**KIRKLEES METROPOLITAN COUNCIL
INVESTMENT & REGENERATION SERVICE**

**DELEGATED DECISION TO DETERMINE APPLICATIONS FOR
CONSENT, AGREEMENT OR APPROVAL REQUIRED BY CONDITION**

Reference No:	2023/44/92049/E
Site Address:	77, Latham Lane, Gomersal, Cleckheaton, BD19 4AP
Description:	Discharge conditions 3 (materials) 4 (boundary treatments) 11 (integral bat box) and 12 (planting) on previous permission 2023/90506 for erection of detached dwelling with integral garage
Recommending Officer:	Nicole Helliwell

Officer Report

Drawing no
22-1185/(AL)01

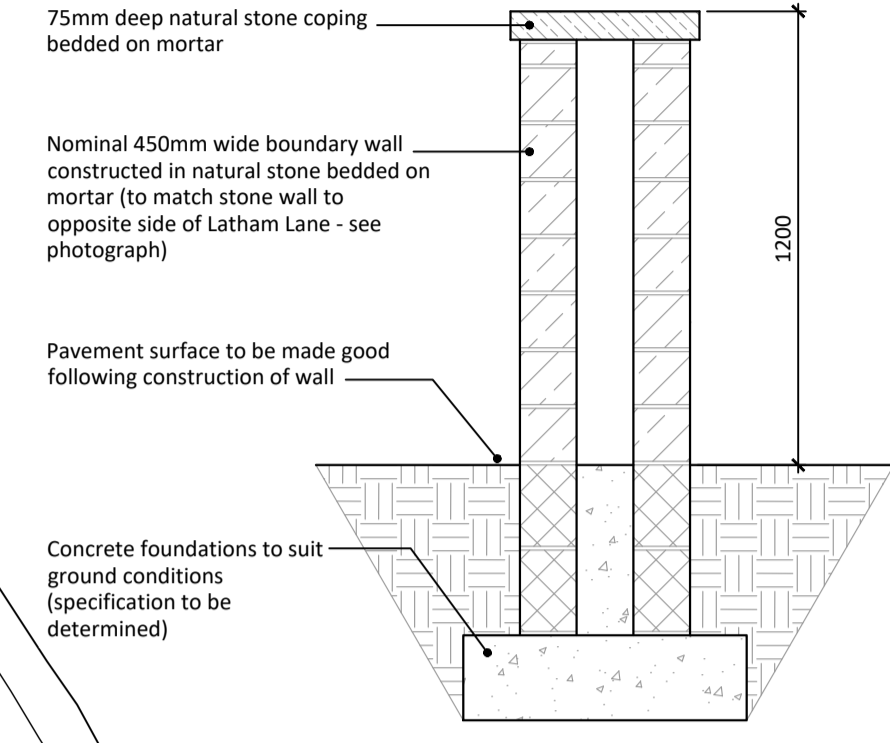
The applicant has submitted 'Site Block & Location Plans As Proposed' dated February 2023 (drawing no. 22-1185/(AL)01, revision C) which detail the location, height and materials of the proposed boundary treatments. This information is considered sufficient to discharge this condition.

The proposed boundary treatment would comprise a dry stone wall to the front of the application site. The wall would measure 1.2m in height and would be constructed in natural stone with flat coping. The proposed boundary treatment would be in keeping with the existing wall at the opposite site of the road and would not cause any significant harm to visual amenity. These details are deemed to be acceptable for the purposes of the condition and therefore condition 4 can be discharged. This is subject to the hereby approved boundary treatment being completed in accordance with the approved detail and thereafter retained.

The applicant has submitted 'has submitted 'Site Block & Location Plans As Proposed' dated February 2023 (drawing no. 22-1185/(AL)01, revision E) which details new native planting proposed within the grounds of the property, in addition to a planting schedule.

These details are deemed to be acceptable for the purposes of the condition and therefore Condition 12 will be discharged by the provision of the approved planting in accordance with the schedule set out on drawing no. 22-1185/(AL)01, revision E.
